A57 Link Roads

TR010034

**9.61 Register of Environmental Statement
Changes**

May 2022

Drawing Title
**FIGURE 11.13
 OPERATION PHASE LONG TERM CHANGE
 WITHOUT THE SCHEME (DSFY-DMOY)**

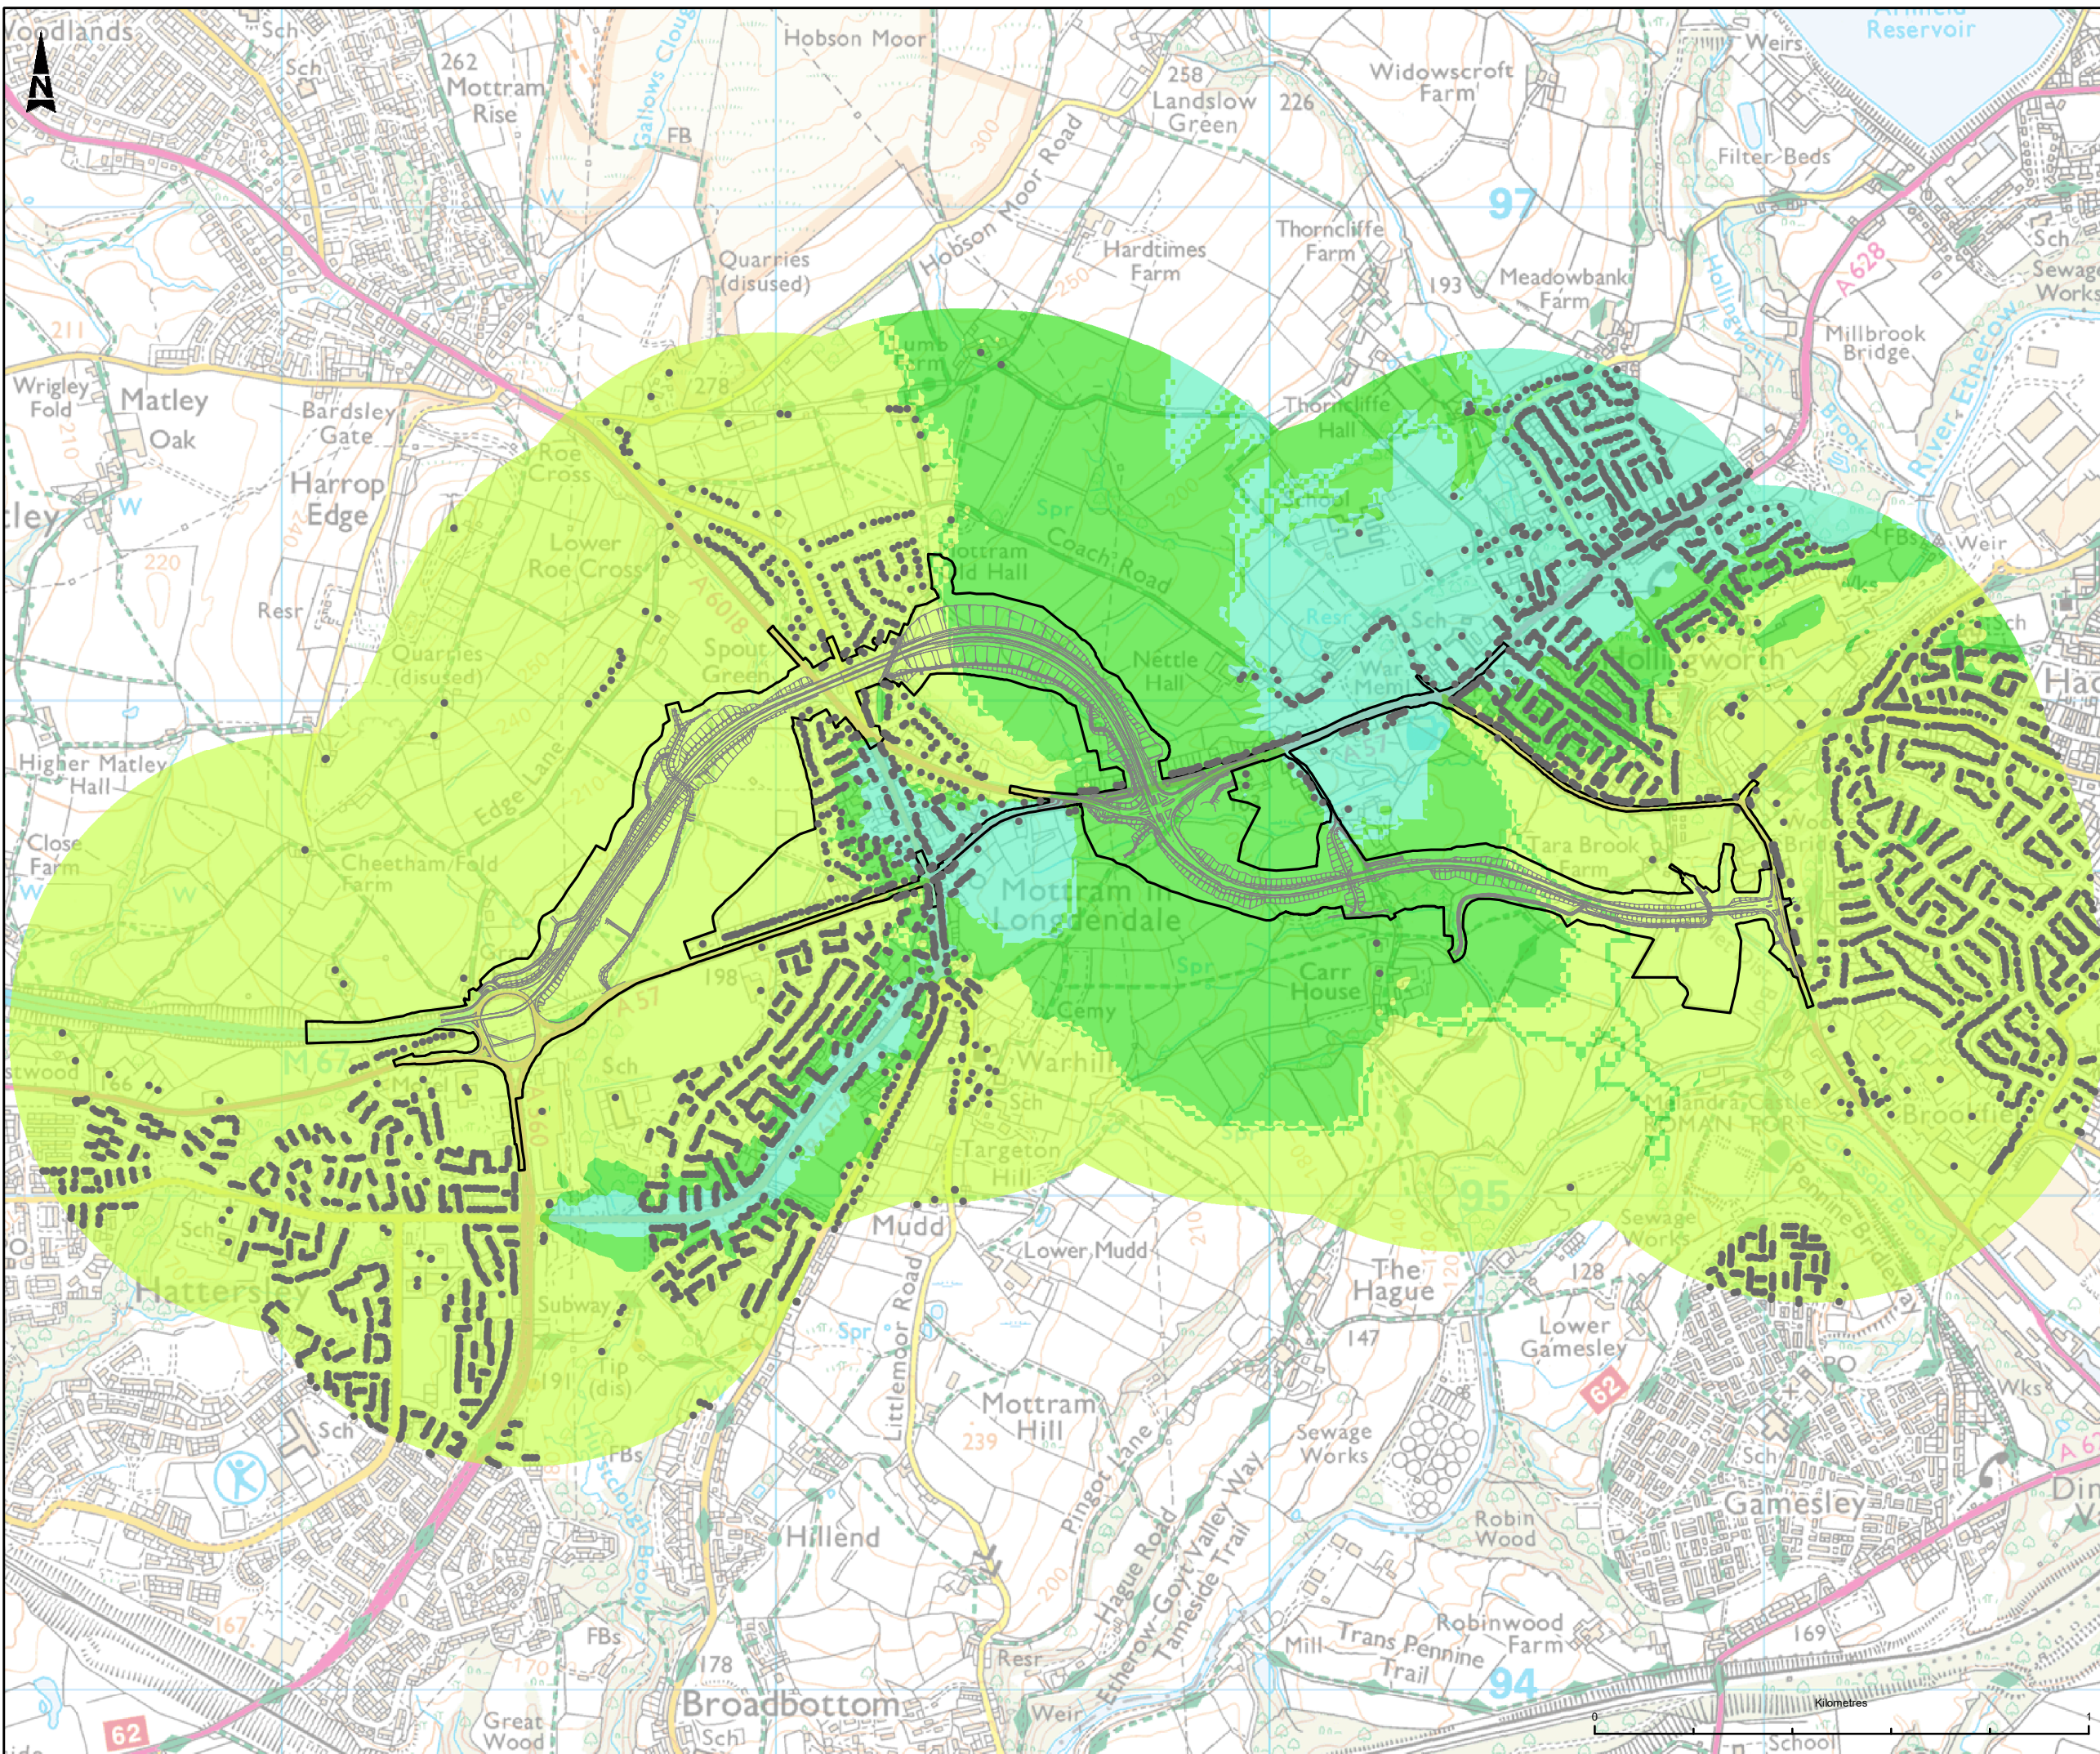
Environmental Statement - Figure 11.13 - Operation Phase Long Term Change without Scheme (DSFY-DMOY)	REP1-028	Updates to ensure Title aligns with data in images	2
Environmental Statement - Figure 11.14 - Operation Phase Do Minimum Opening Year Night Noise Levels	REP1-029	Updates to figure legend to correct errors	2
Environmental Statement - Figure 11.15 - Operation Phase Do Something Opening Year Night Noise Levels	REP1-030	Updates to figure legend to correct errors Length of noise barriers updated to align with the design drawings (2.3 Works Plans) submitted	2
Environmental Statement - Figure 11.16 - Operation Phase Do Minimum Future Year Night Noise Levels	REP1-031	Updates to figure legend to correct errors	2
Environmental Statement - Figure 11.17 - Operation Phase Do Something Future Year Night Noise Levels	REP1-032	Updates to figure legend to correct errors Length of noise barriers updated to align with the design drawings (2.3 Works Plans) submitted	2
